DELEGATED HOUSEHOLDER DECISION

Item No.	Report of the Head of Development Management and Building Control	
Address:	32 ICKENHAM ROAD RUISLIP	
Development:	Erection of a two storey rear extension, part single part two storey front extension, first floor side extension and installation of rooflights. (Description amended)	
LBH Ref Nos:	12766/APP/2024/1224	
Drawing Nos:	24011-REP-001 - Rev 1 24011-FSS-001 - Rev 1 24011-PLA-001 - Rev 1 24011-PLA-002 - Rev 1 24011-PLA-007 - Rev 1 24011-PLA-008 - Rev 1 24011-PLA-009 - Rev 1 24011-PLA-010 - Rev 1 24011-PLA-005 - Rev 1 24011-PLA-006 - Rev 1 24011-PLA-004 - Rev 1 24011-PLA-003 - Rev 1	
Date Plans received:	08-05-24	Date(s) of Amendments(s):
Date Application valid	08-05-24

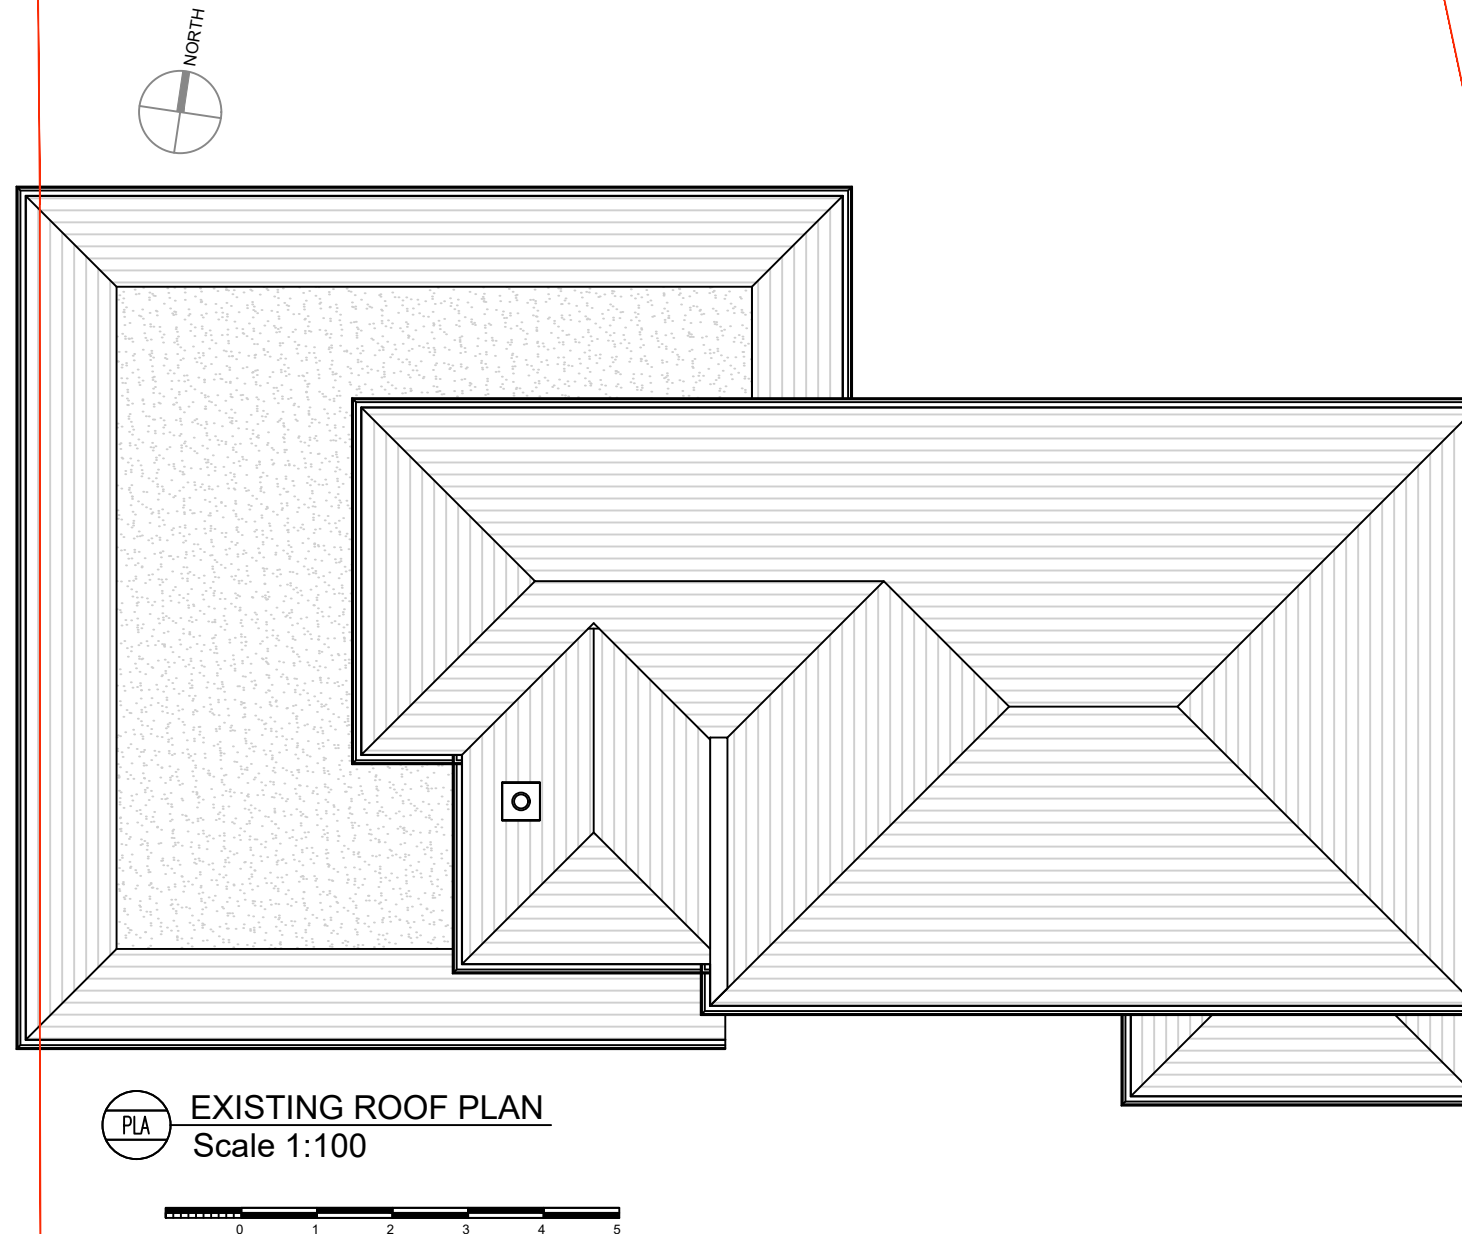
- The first floor side extension should be set in further to maintain the clear gaps between the dwellinghouses, preventing a terracing effect.
- Concern over the massing of the front extension and the impact this would have on the appearance of the property within the conservation area.

In addition, the proposal would alter the existing single storey side extension with the addition of a first floor side extension, nearly double the width of the original dwelling (based on the original property plans from 1956) , contrary to Policy DMHD 1 of the Hillingdon Local Plan: Part 2 (2020). The side extension would set back from the front elevation by around 3.30m and set back from the closest neighbouring boundary by around 1.00m, complying with the requirements of policy DMHD 1. However the the built form would encroach closer to the neighbouring dwelling and would have a enclosing impact on the street by the loss of the existing ample gap. This issue was raised by the conservation officer as causing less than substantial harm to the significance of the conservation area, which could not be out weighed by public benefit. Therefore, on balance the first floor side extension is considered to be contrary to the objectives set out in policy DMHB 1, DMHB 4, DMHB 11 and DMHD 1 which require extensions to be sympathetic to the host property, surrounding neighbouring properties and designated heritage assets such as conservation areas.

The combination of the first floor front extension and the single storey front extension would create a bulky addition to the front of elevation which would be contrary to the objectives of policy DMHD1 and would a negative impact upon the character and appearance of the property within the conservation area. Based on observations and planning history of neighbouring properties there does not seem to be other examples of large front extensions within the locality.
